Application No. H11/0026/02

**RE: RESIDENTIAL DEVELOPMENT (3 NO. PLOTS) ADJACENT 33 STATION ROAD
LONG SUTTON FOR DAY & HAMMOND BUILDINGS LTD**

Amendment 2
Application No. H11/0026/02

Site/Subject PLOT 3 DOT. OFF STATION ROAD LONG-ATTEN

1:200 1:2500 DH01-002/1
NOV-01 B.GILHAM.

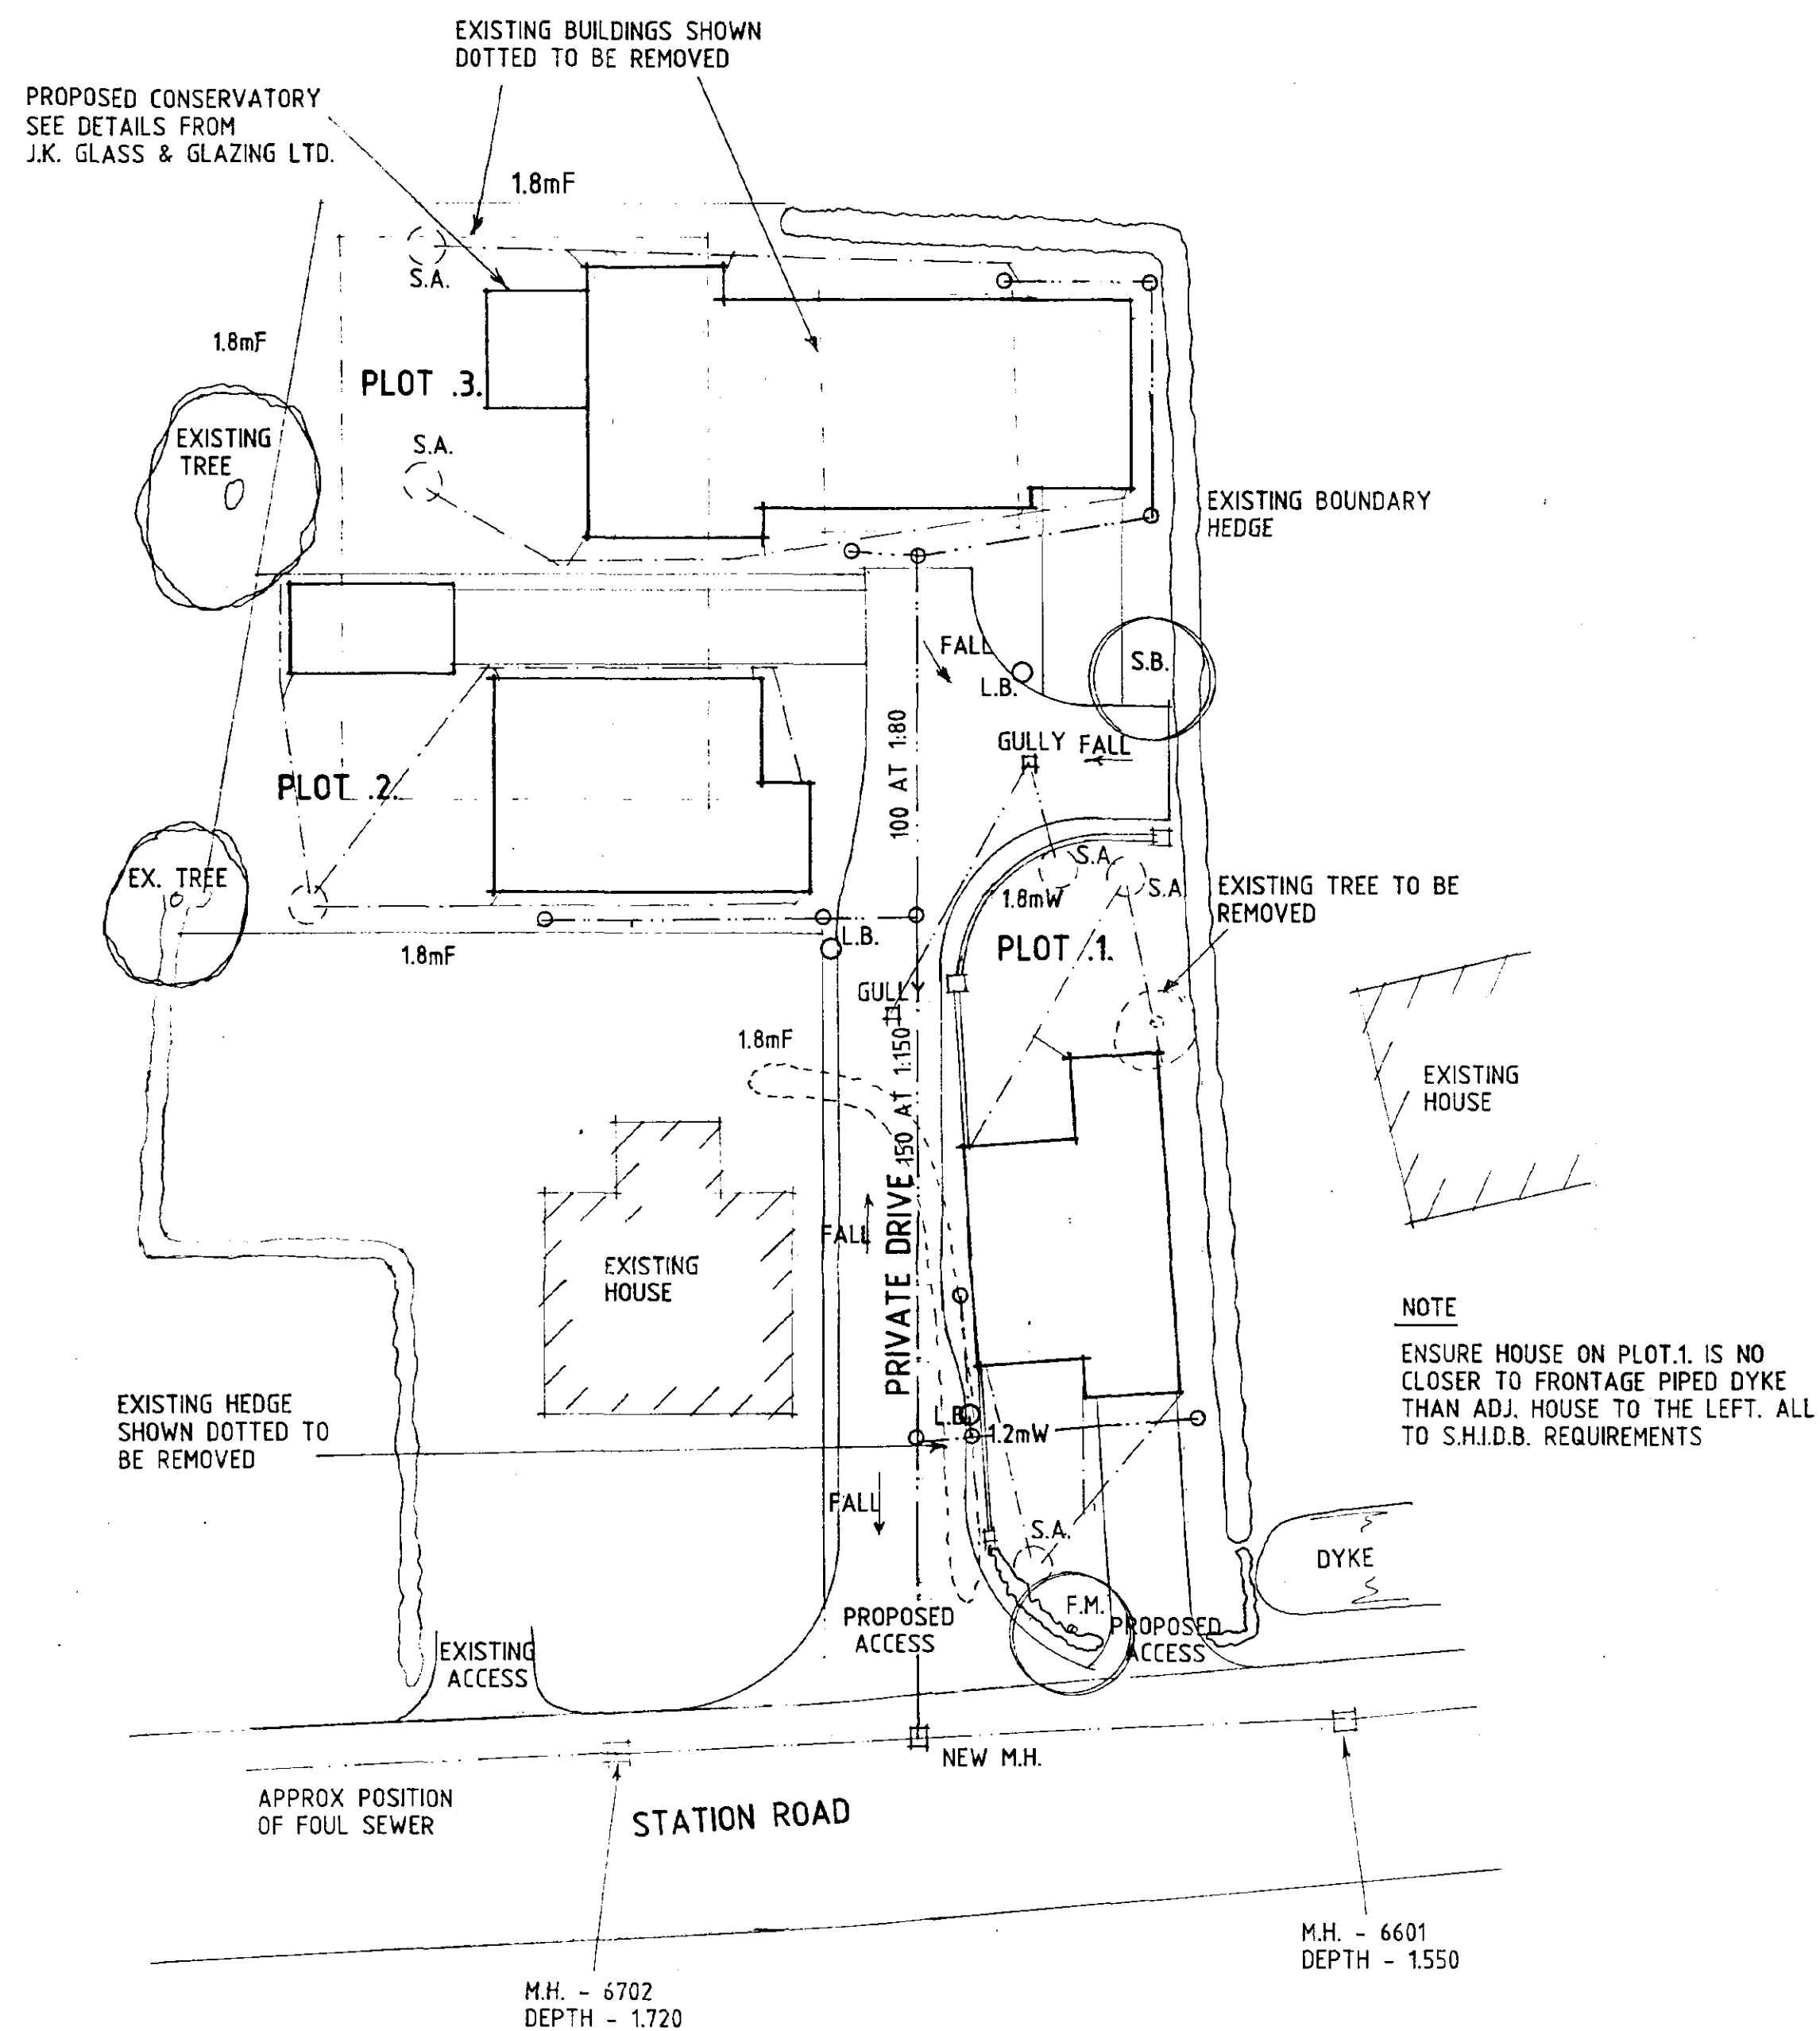
Speak to J. Sheppard
re. parking
loss of garage
want revised plan
indicating parking

This site has been very tight for space from the outset.

The drive for Plot 3, as shown on App. D1101-002/1, is not long enough for two cars to park. There could be a problem with vehicles from or visiting this plot, obstructing the turning area.

An alternative may be to pave the frontage of Plot 3 so that vehicles could be parked side by side in two 5m x 2.5m spaces.

Can you have a quick check of this drive design. Plot 3 proposed to use garage as storage, removing garage space concern re. space within the site for turning head + parking space for plot 3

There should be space to park 2 cars in front of Plot 3 + have a turning area?
